Our ref: **INVALID APPLICATION ACKNOWLEDGEMENT**  
GCC Application Ref: **23/02158/FUL**

**SITE: Flat 0/2 702 Edgefauld Road Glasgow G21 4NB**

**PROPOSAL: Use of flatted dwelling (Sui Generis) as short term let (Sui Generis)**

FLAT 2 702 EDGEFAULD ROAD FLOOR PLAN

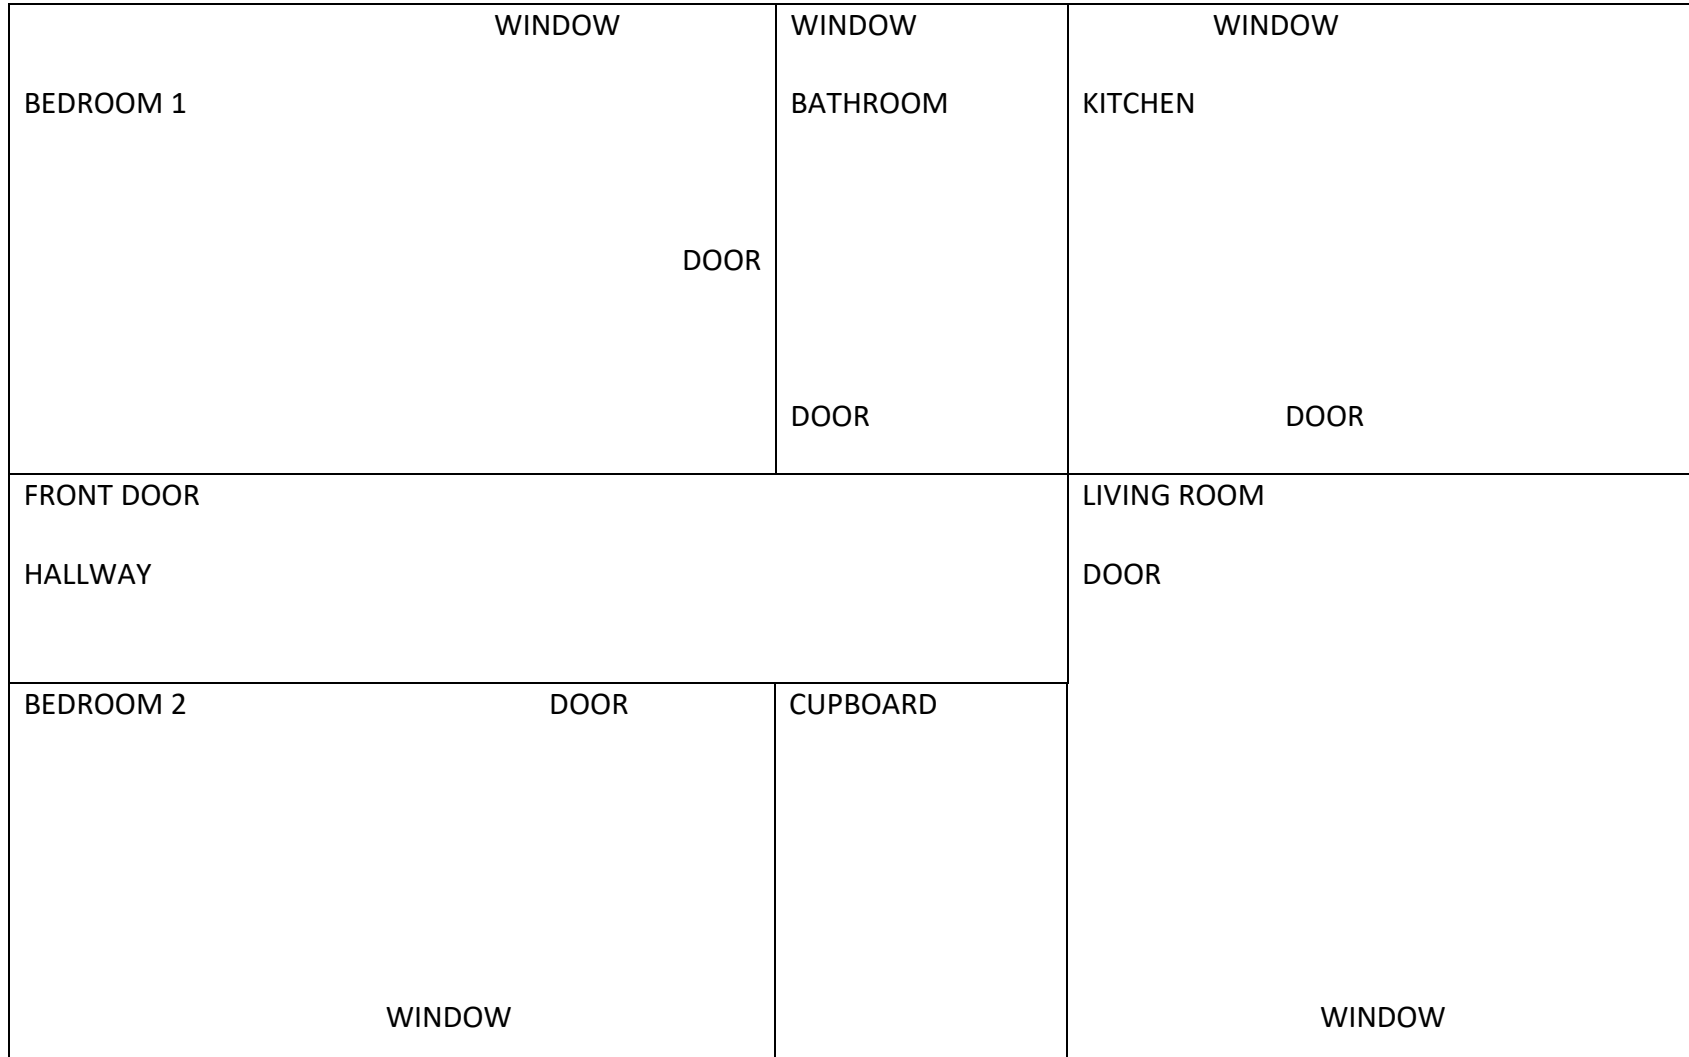
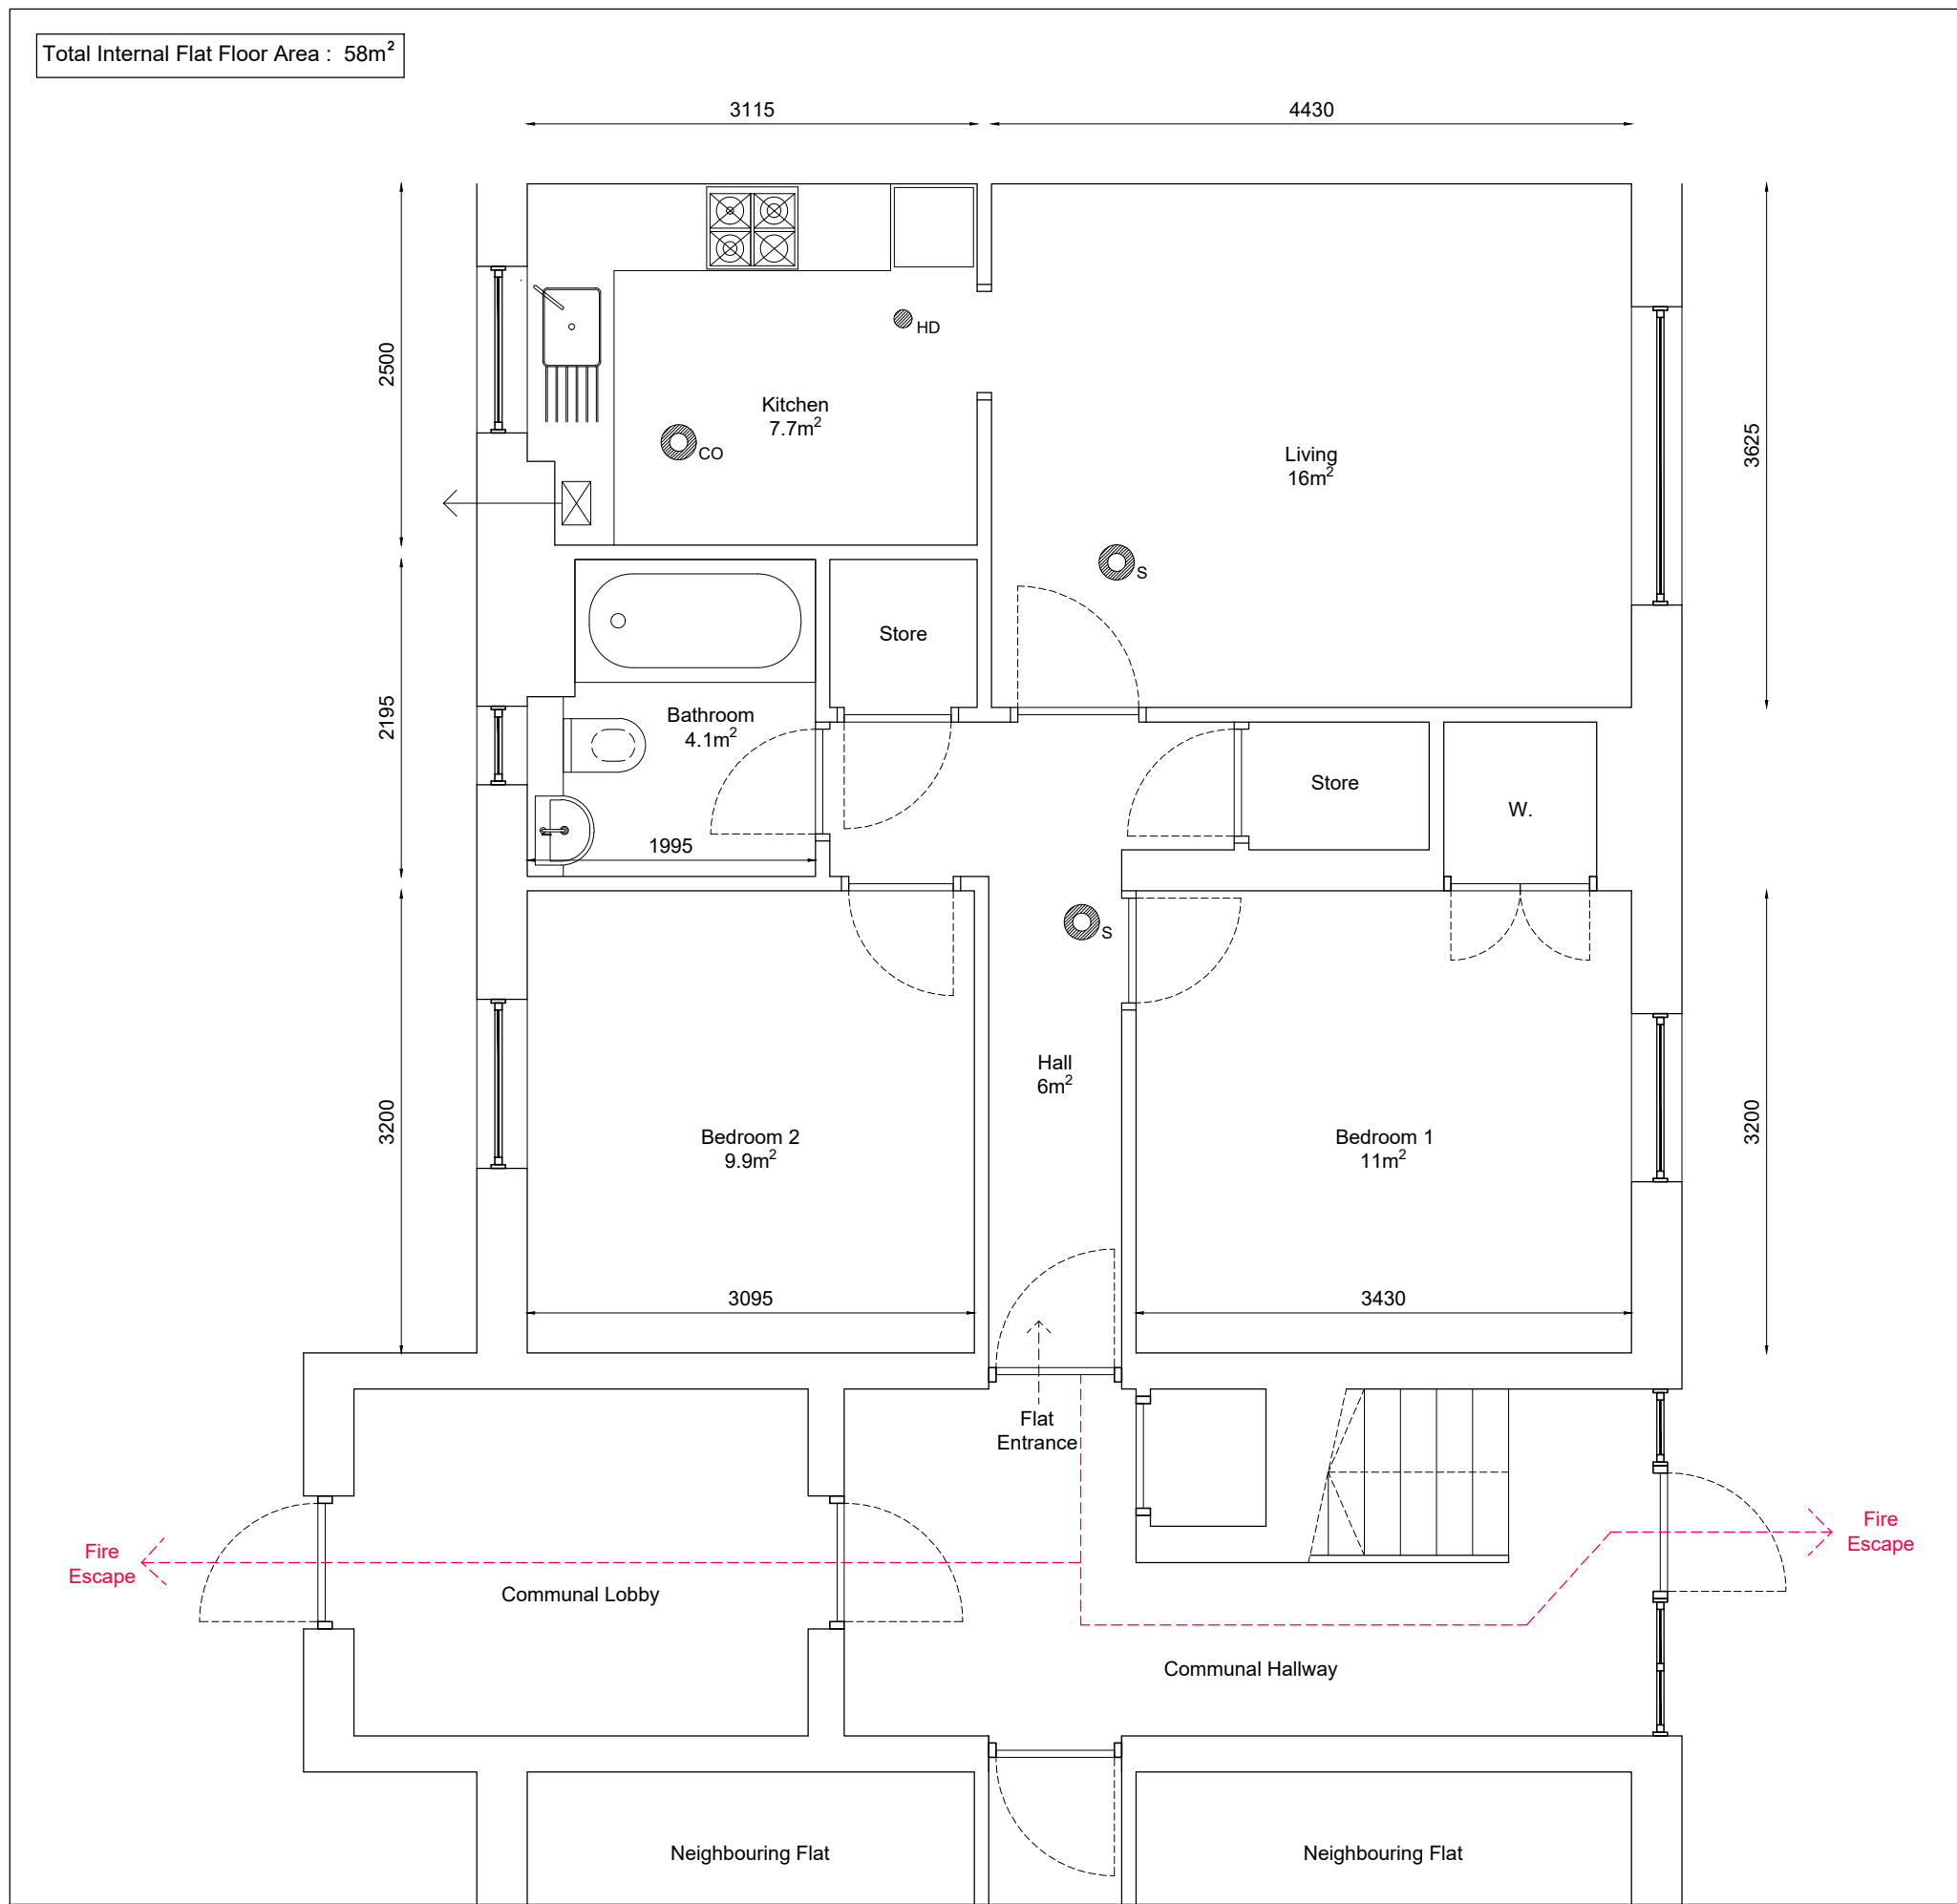
004 Please submit the following plans/drawings as are necessary to describe the development to which the application relates:-

Scaled floor plan with gross floorspace in sqm.

005 Please add a scale bar to all drawings/plans submitted as part of the application.
